A303 Amesbury to Berwick Down

TR010025

Deadline 7
8.45 - Errata Report

ERRATA Report

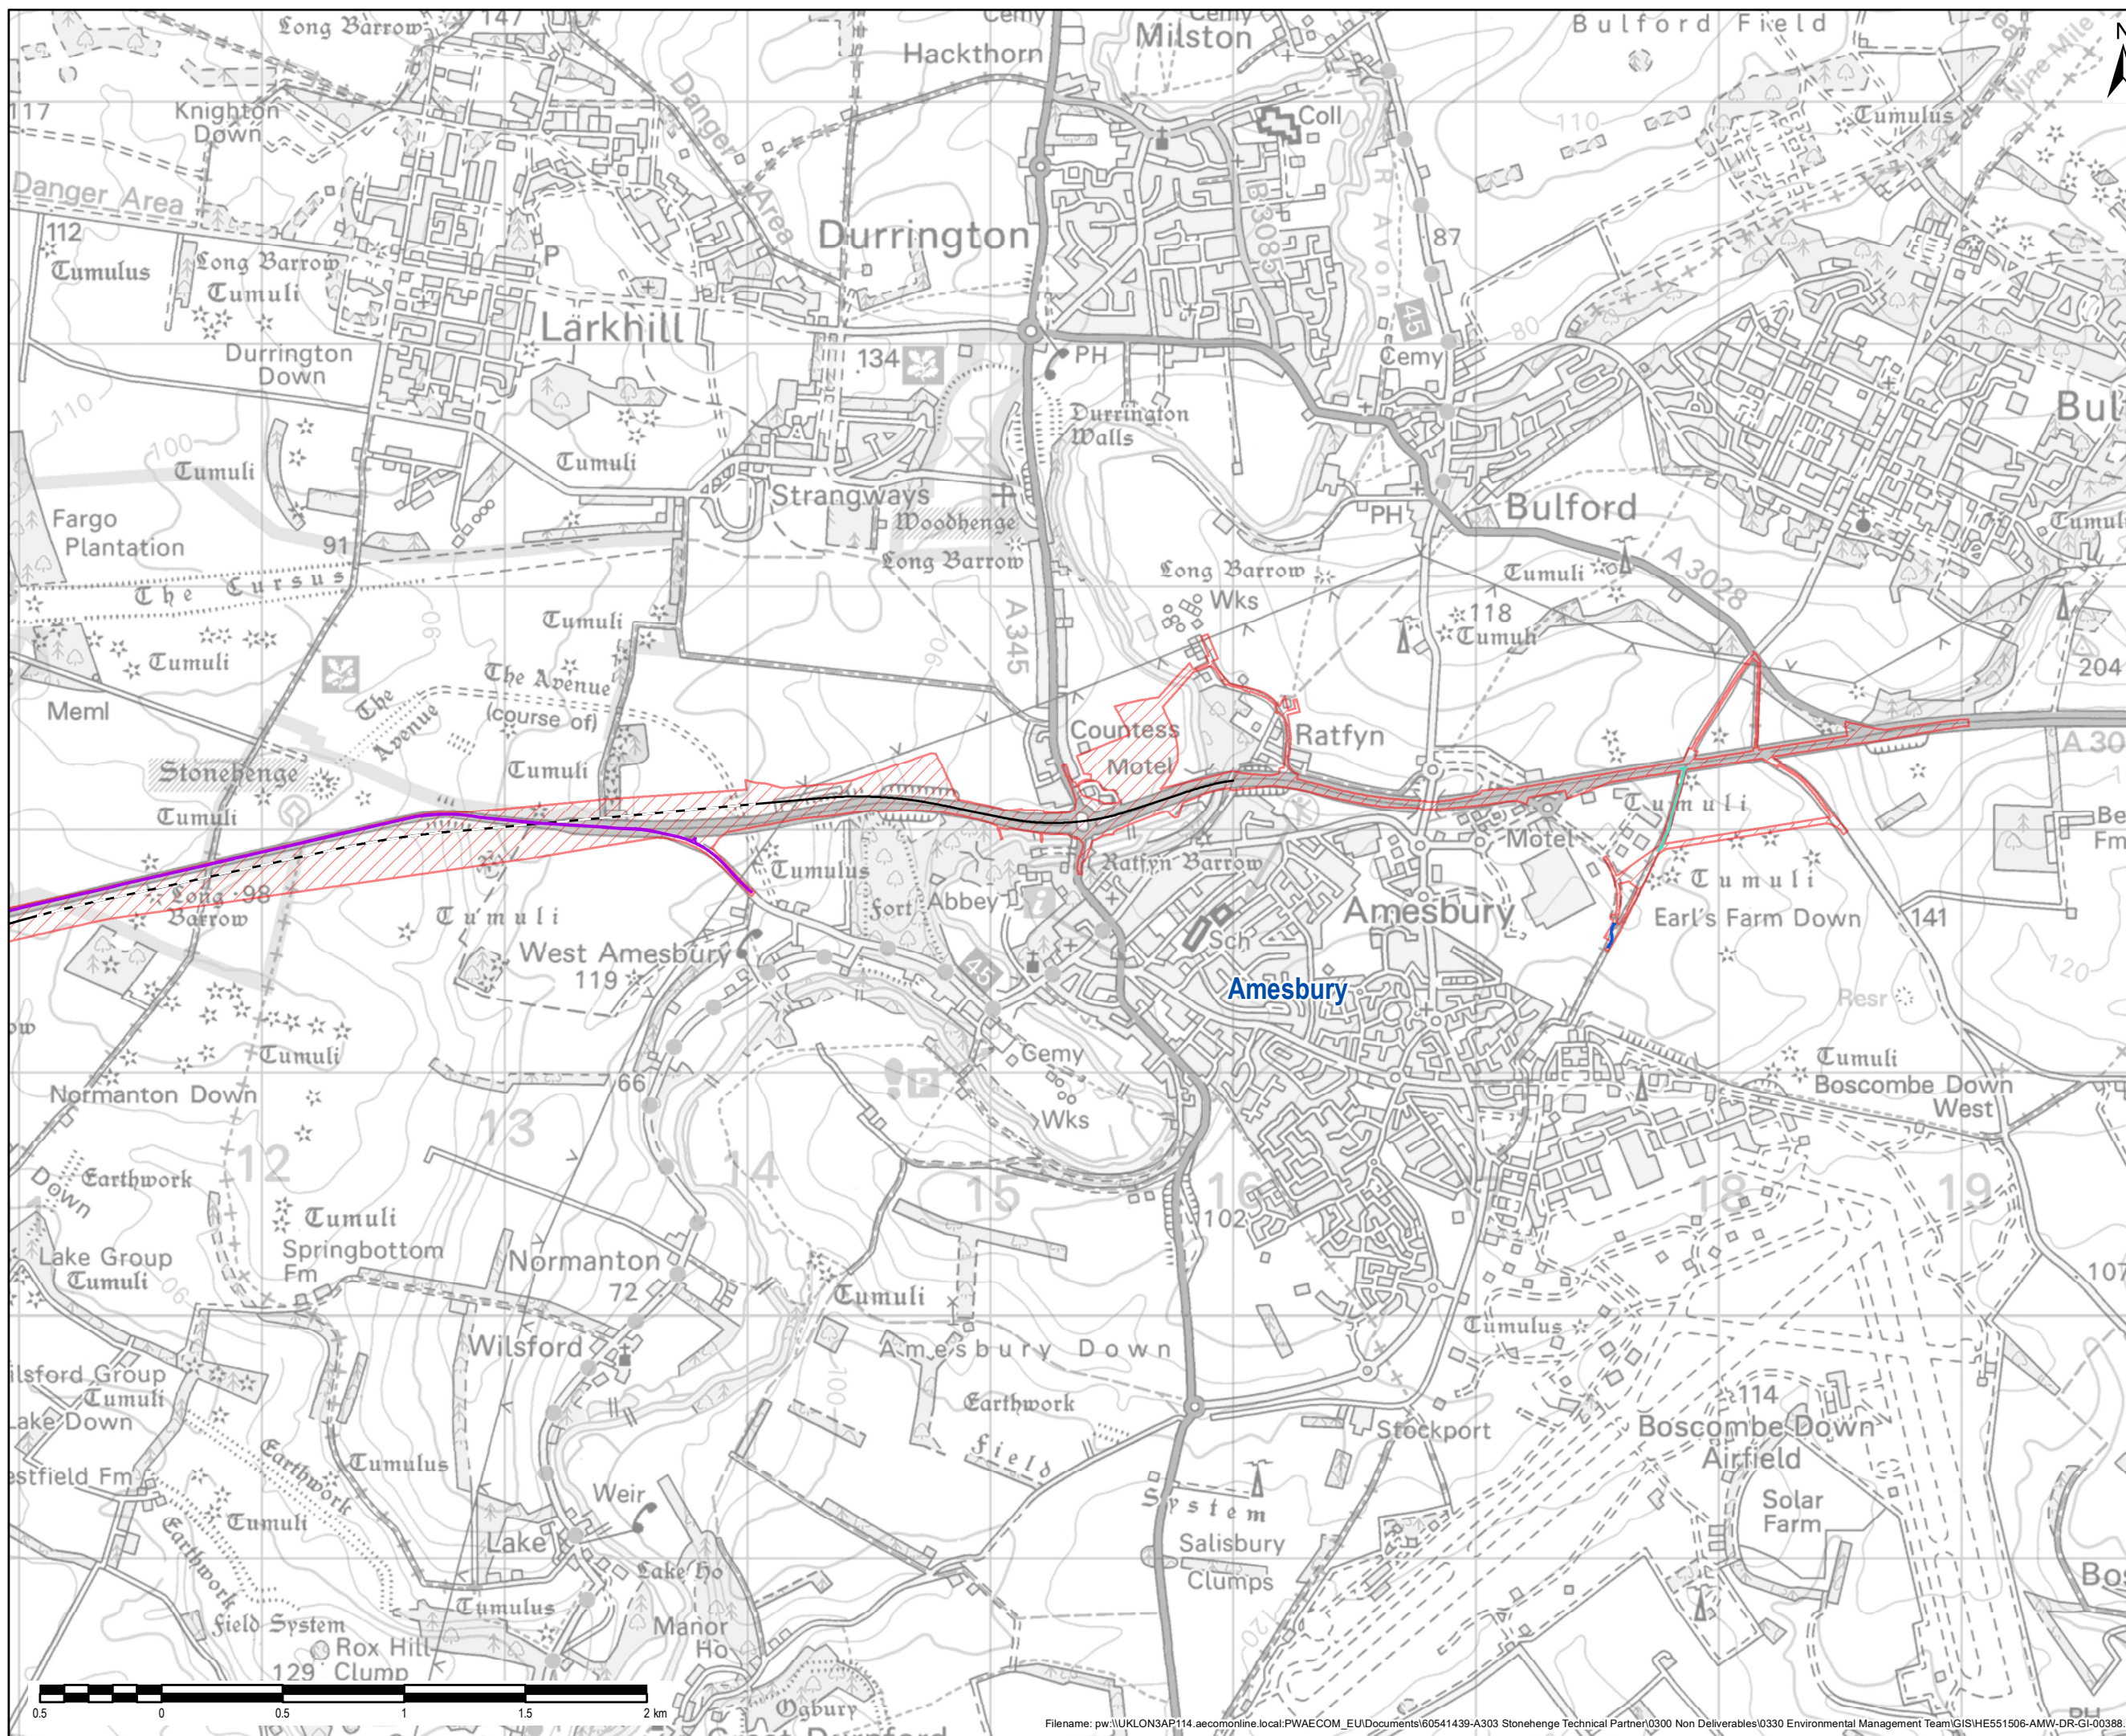
Document no.	Document name	Section and Paragraph Reference	Nature of Erratum and Explanation	Replacement Text
APP-180	ES Chapter 13	Figure 13.2	Error in Figure title	<p>The title of the Figure should be amended as shown:</p> <p>“FIGURE 13.2 EXISTING NMU ROUTES PUBLIC RIGHTS OF WAY”.</p> <p>The corrected figure is provided in Appendix A of this Report.</p>
APP-181	ES Chapter 13	Figure 13.3 A and B	Error in Figures	<p>The title of the Figure should be amended as shown: “FIGURE 13.3A EXISTING NMU ROUTES PUBLIC RIGHTS OF WAY”.</p> <p>The title of the Figure should be amended as shown: “FIGURE 13.3B EXISTING NMU ROUTES PUBLIC RIGHTS OF WAY”.</p> <p>The following errors as shown within the extracts below have been identified in Figures 13.3A and 13.3B. The corrected figures are provided within Appendix A of this Report. To confirm, these are drafting errors only and do not affect the conclusions of the assessment presented within Chapter 13 of the ES.</p>
